City of Albuquerque

**RE: FedEx Ground ABQ Drainage Report and Grading Plan and Drainage Plan
Engineer's Stamp Date 8-12-14 (K09D026A)**

Per correspondence from your office dated September 2, 2014, please find the following responses addressing the drainage comments listed below:

DRAWN BY
DY
DATE
7-22-14
2013075-GRE
SHEET #
GR-1
JOB #
2013075

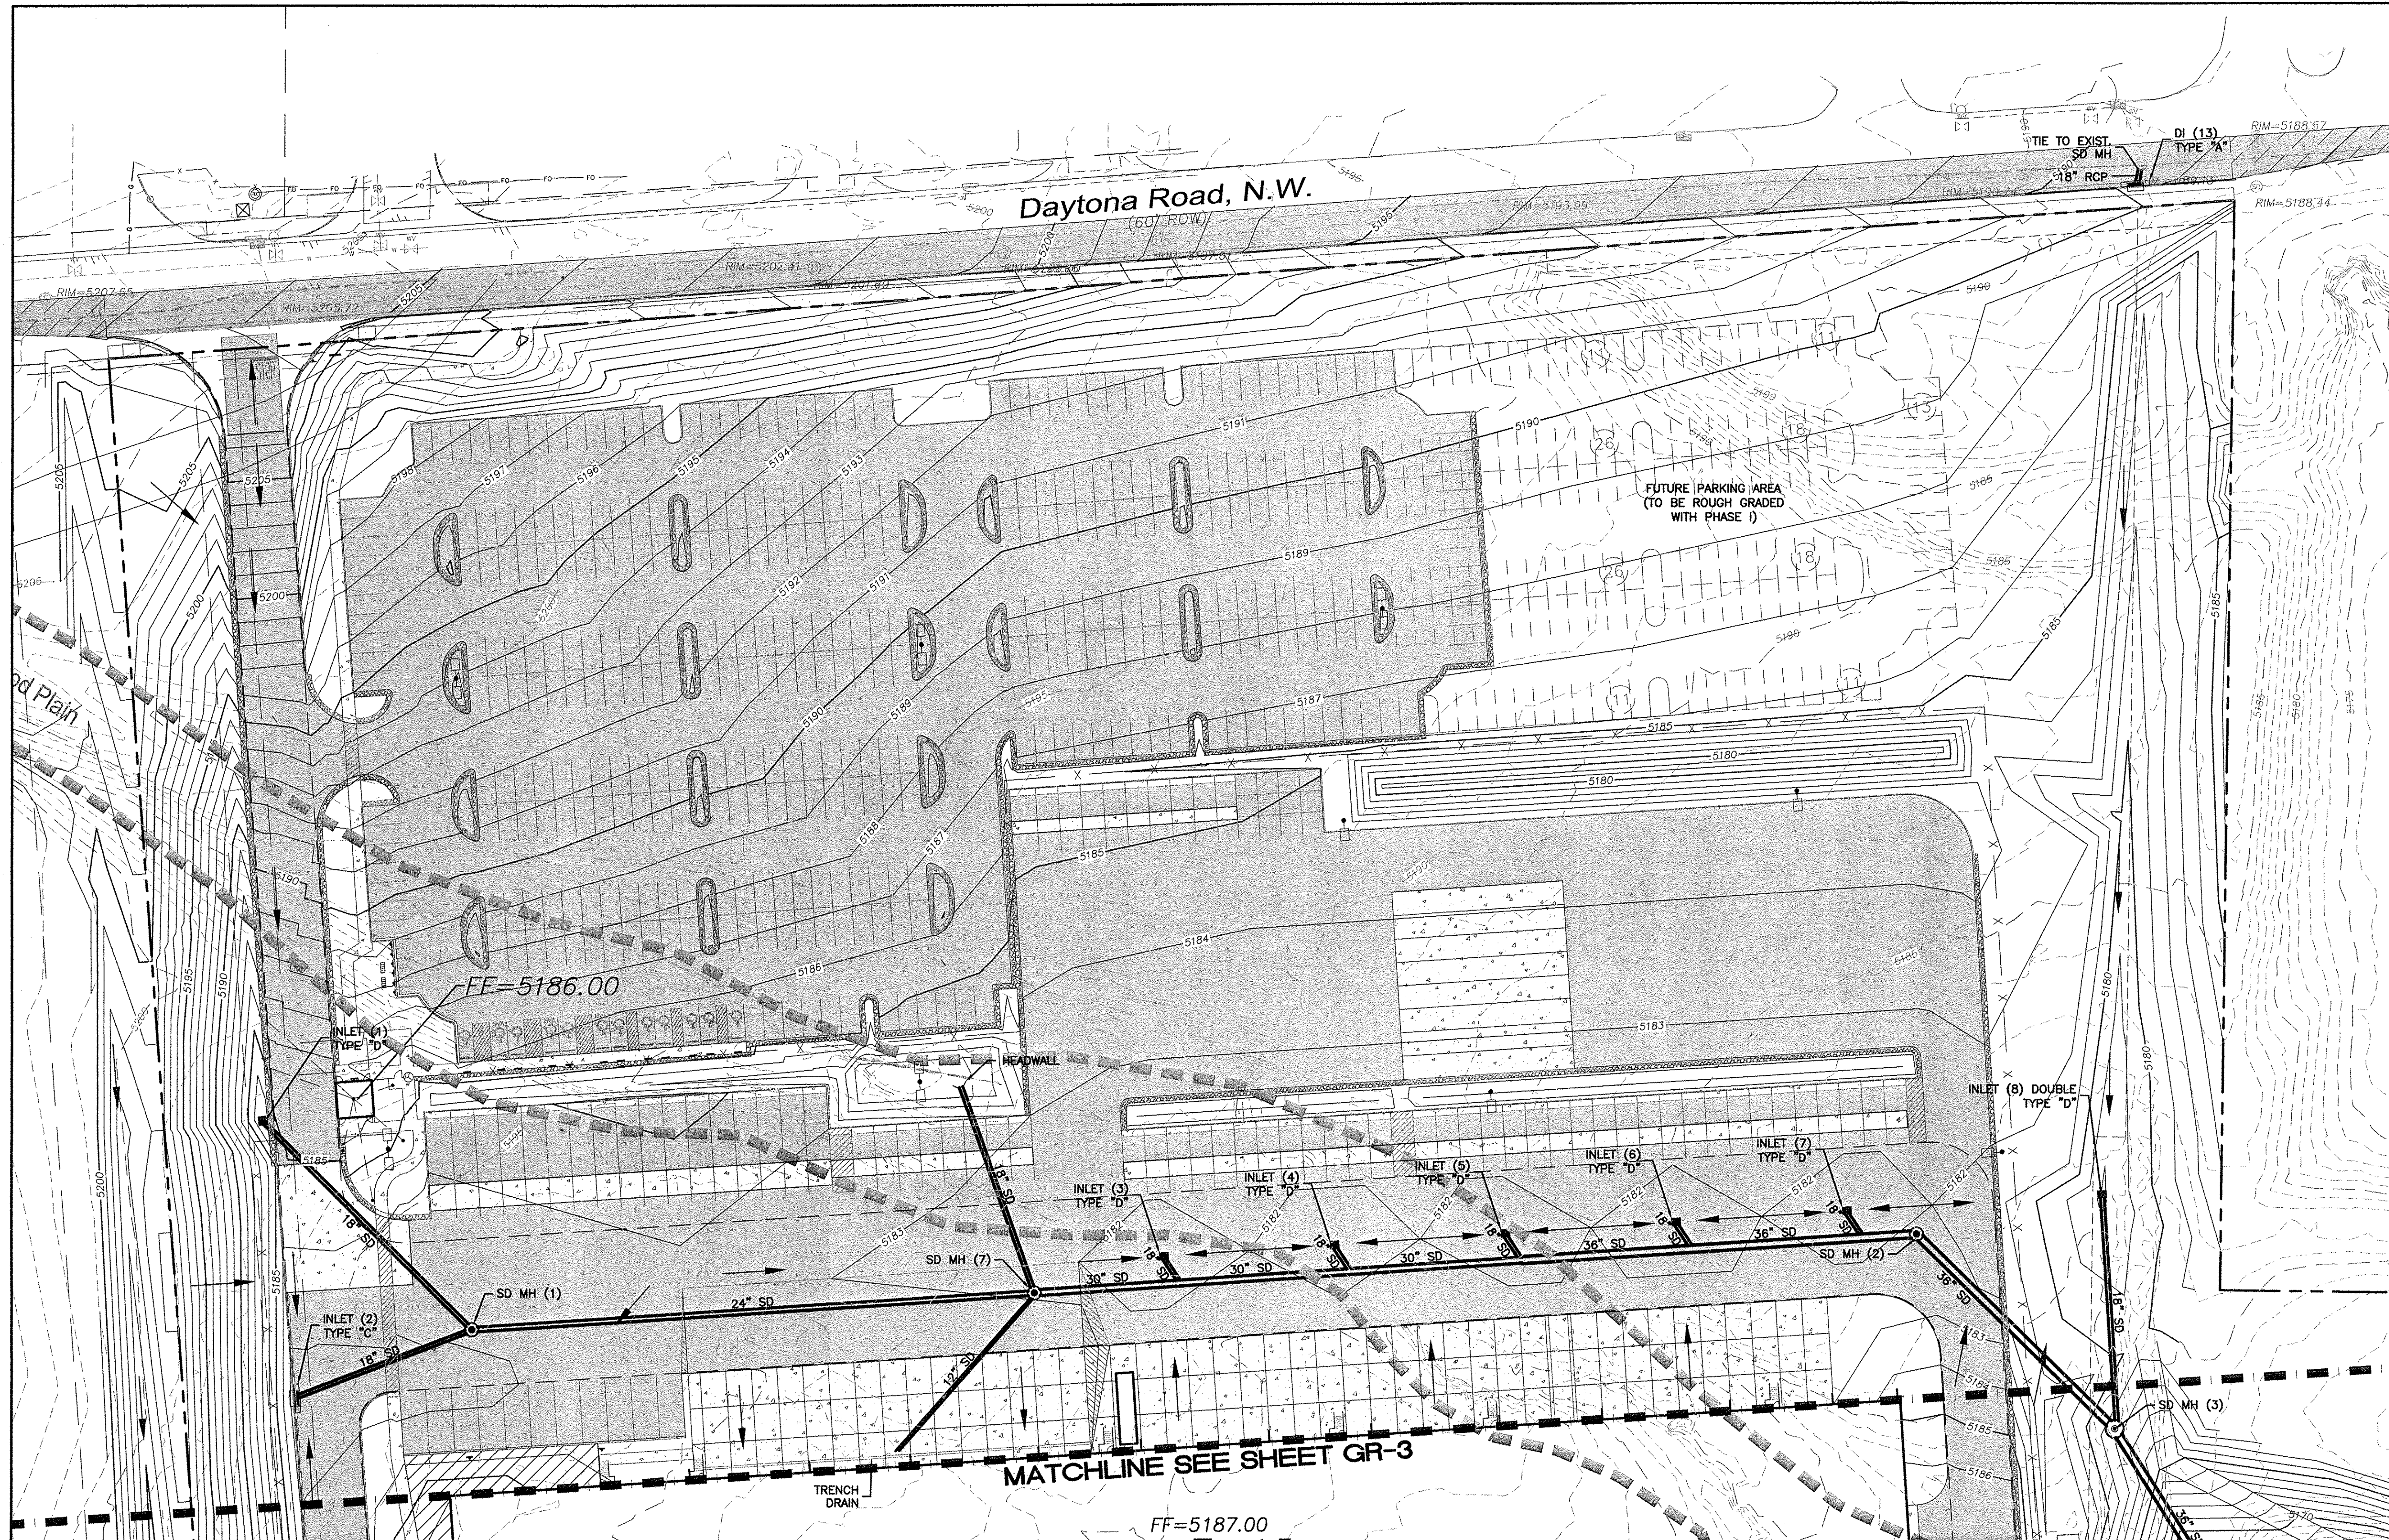
9. Provide headwall details for the four headwalls called out on the plans. What are the inverts of the storm drains going into Pond 5? What is the invert of the storm drain in the small pond north of the proposed building? Include riprap for the design of the desiltation pond north of Los Volcanos since a significant amount of flow will be entering that pond. Have the pond slopes outside the 5 foot PUE.

Response: A headwall detail and inverts for were added to the plans. Riprap was added at the desilting pond at Los Volcanes and the pond slopes were moved outside the 5' PUE.

RONALD R. BOHANNAN P.E. #7868	FEDEX GROUND ALBUQUERQUE, NM	ENGINEER'S SEAL	DRAWN BY DY
			DATE 7-22-14
	GRADING AND DRAINAGE PLAN		2013075-GRE
	TIERRA WEST, LLC 5571 MIDWAY PARK PLACE NE ALBUQUERQUE, NM 87109 (505) 858-3100 www.tierrawestllc.com		SHEET # GR-3
			JOB # 2013075

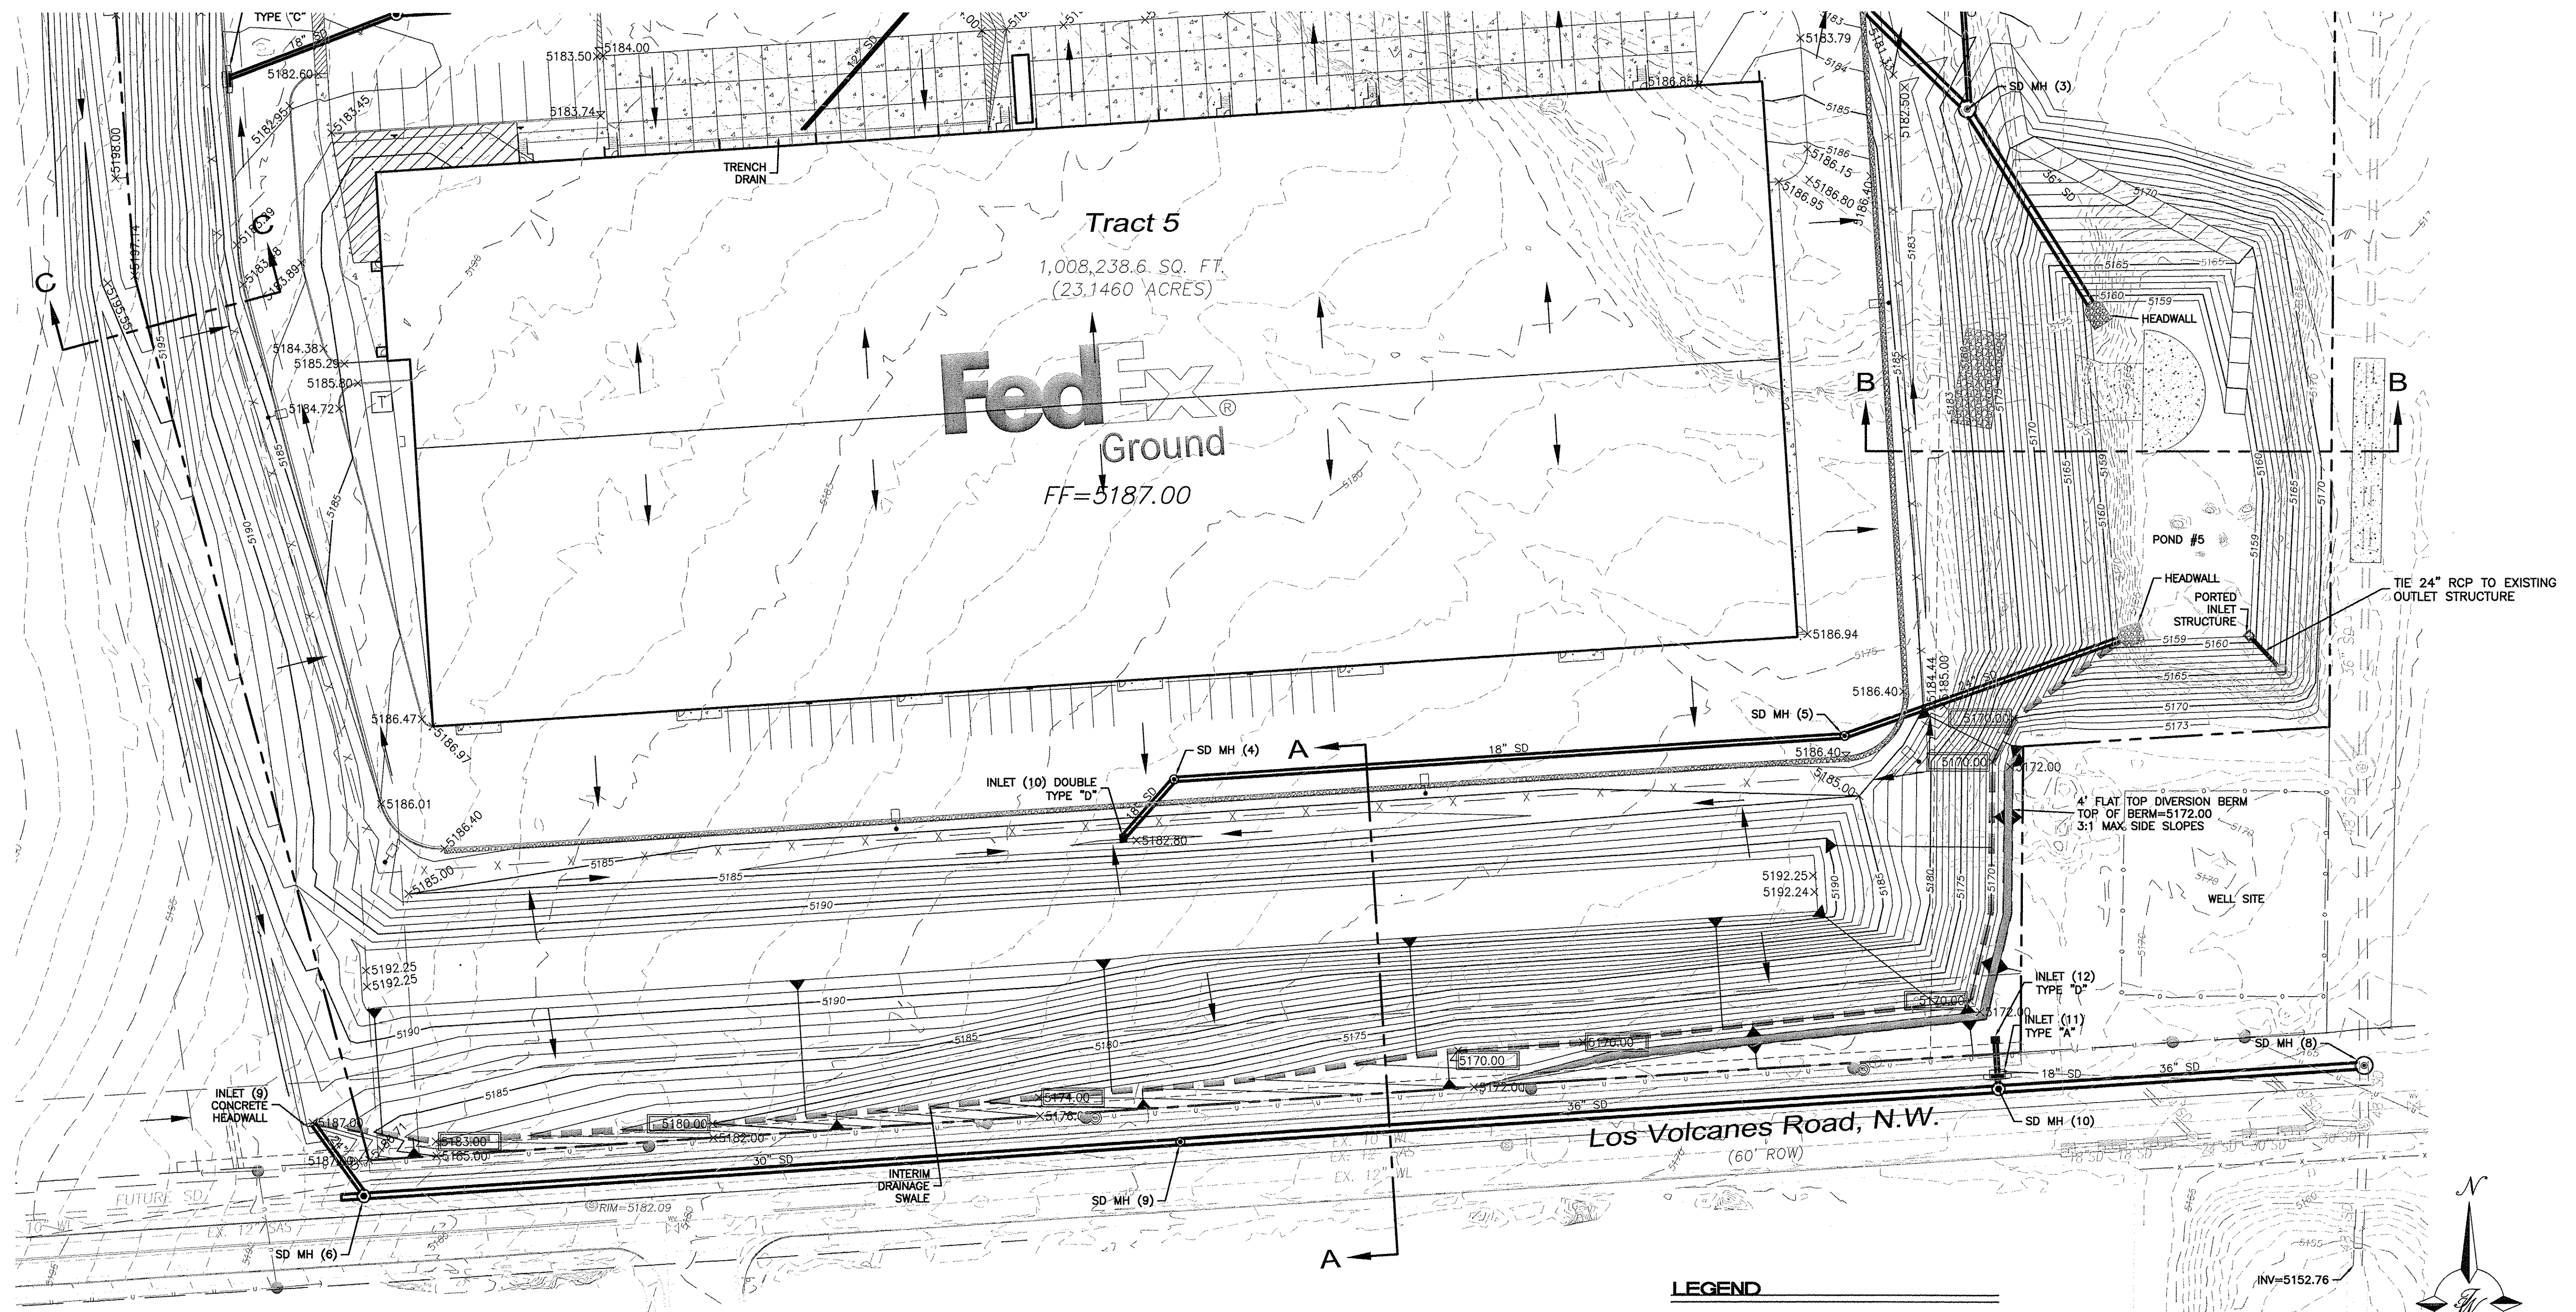
5. What is the total surface flow in Los Volcanos including the existing conditions of the off-site basins that contribute to it once this site is developed? Provide the street capacity for the flow in Los Volcanos Road once this site is developed. Provide the calculations for inlets 11 and 14. Show inlet 14 on the Post Developed Drainage Basin Map. On GR-3, show what storm drains will be abandoned with CPN 655784.

Response: Street and inlet capacity calculations were added to the report. Inlet 14 was added. The maximum flows in Los Volcanes after this development are 8.7 cfs for the half street section which is below the street capacity. Storm drain laterals that will be abandoned with CPN 655784 are noted on the plans.

POND 5 OUTLET STRUCTURE MODIFICATION DETAIL
NTS

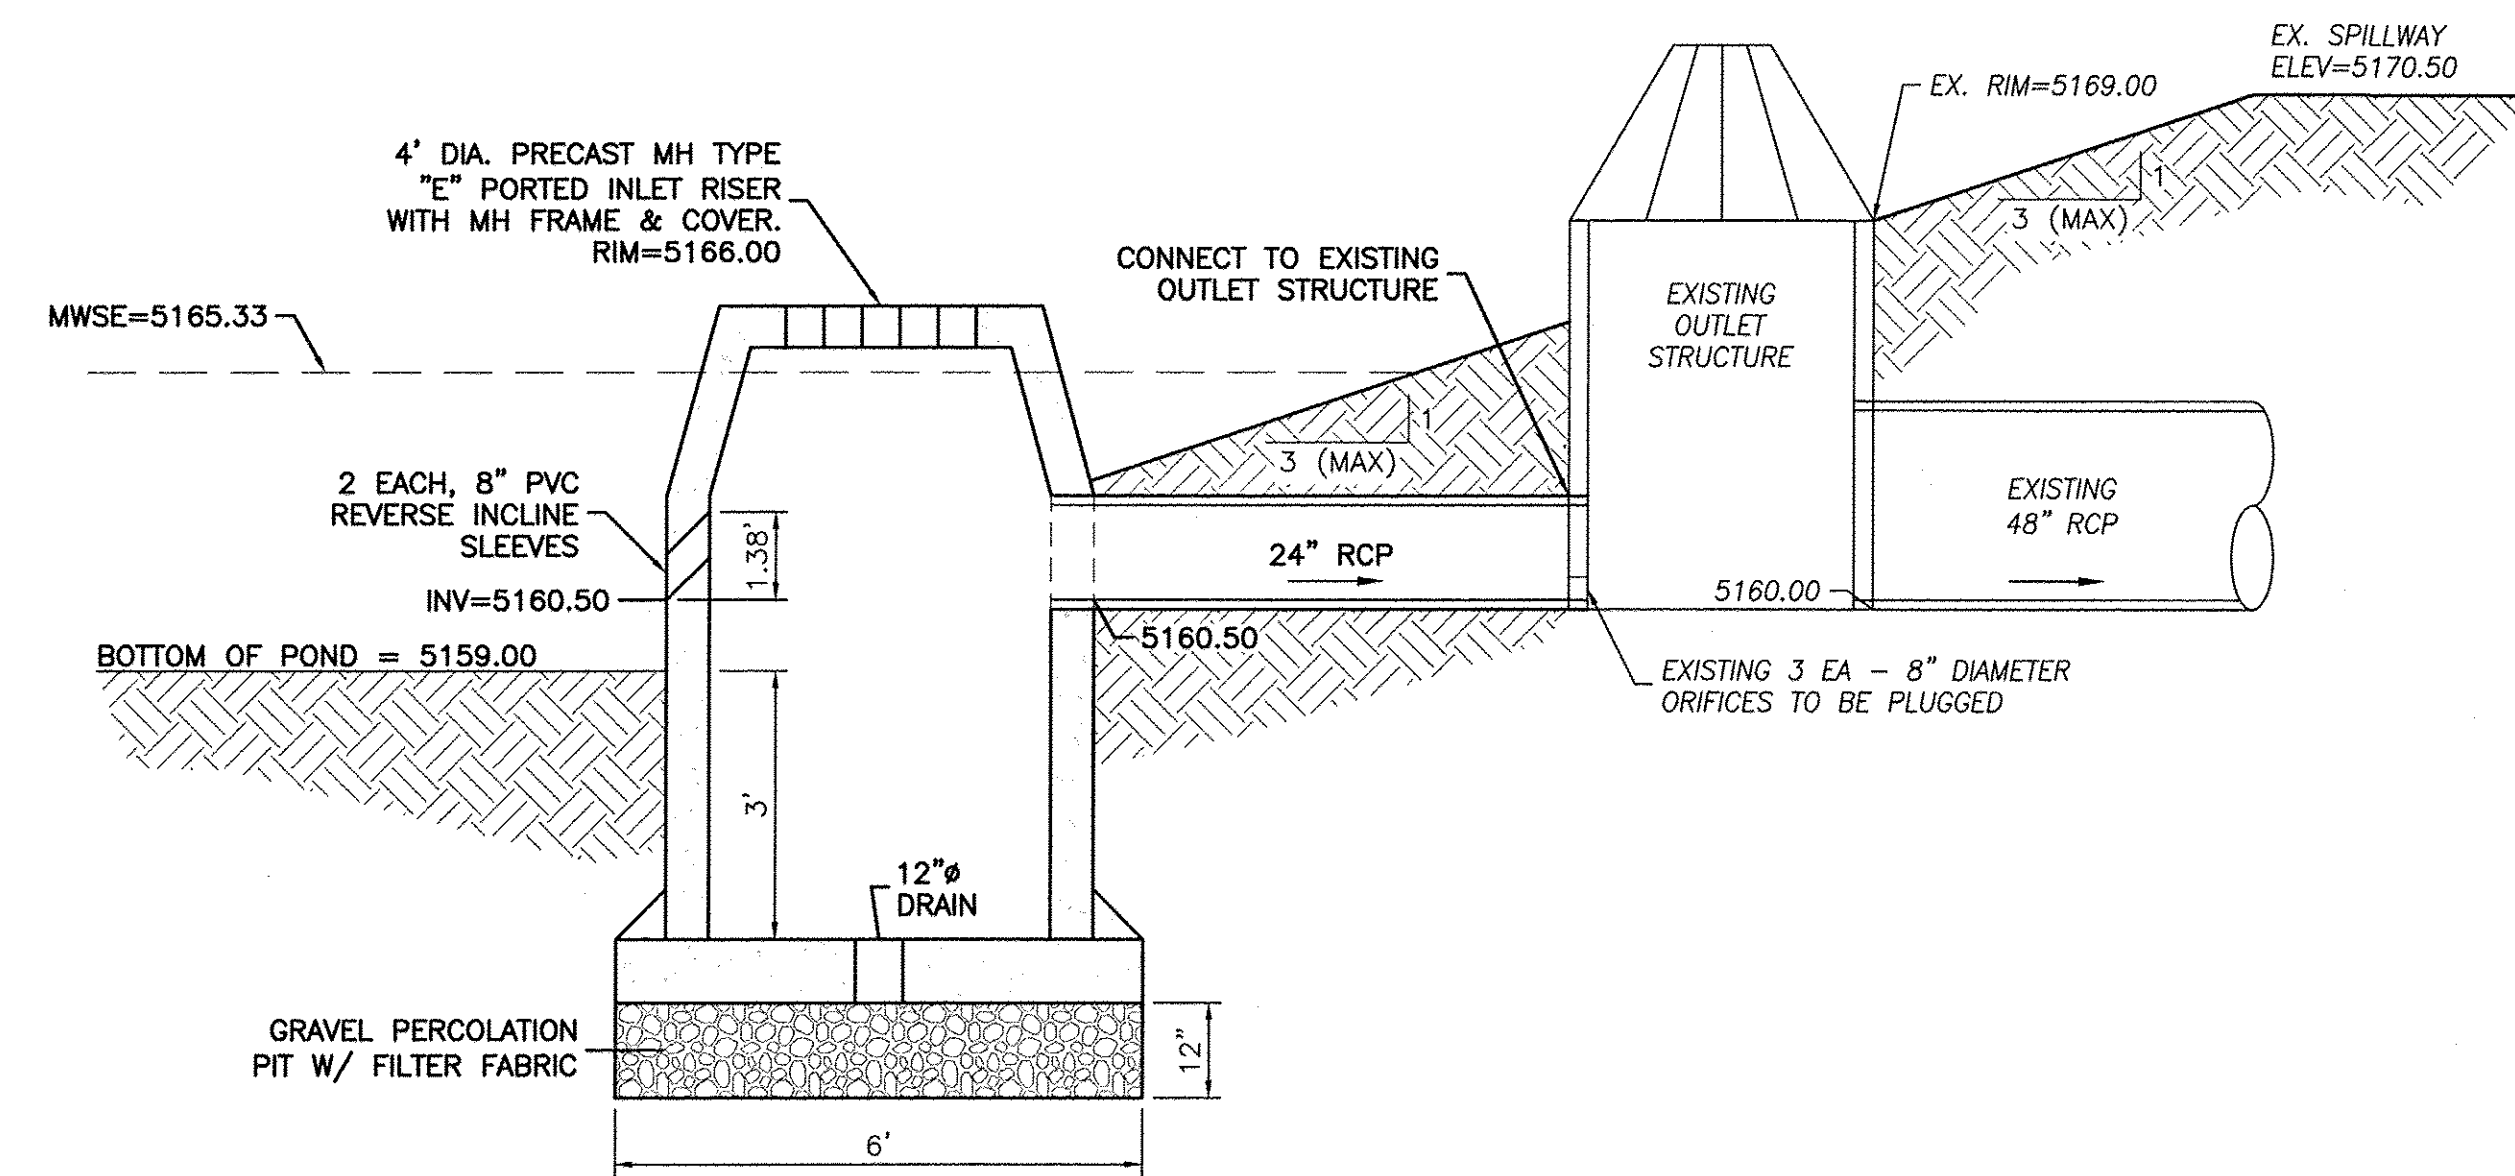
10. On GR-5, what is the invert of the 24 inch entering the existing outlet structure? What is the length of the 24 inch storm drain? Show one foot of cover minimum over the 24 inch storm drain. Instead of plugging the existing 3 orifices in the existing outlet structure, provide an opening for the new 24 inch pipe.

Response: Requested information was added to the outlet structure detail.
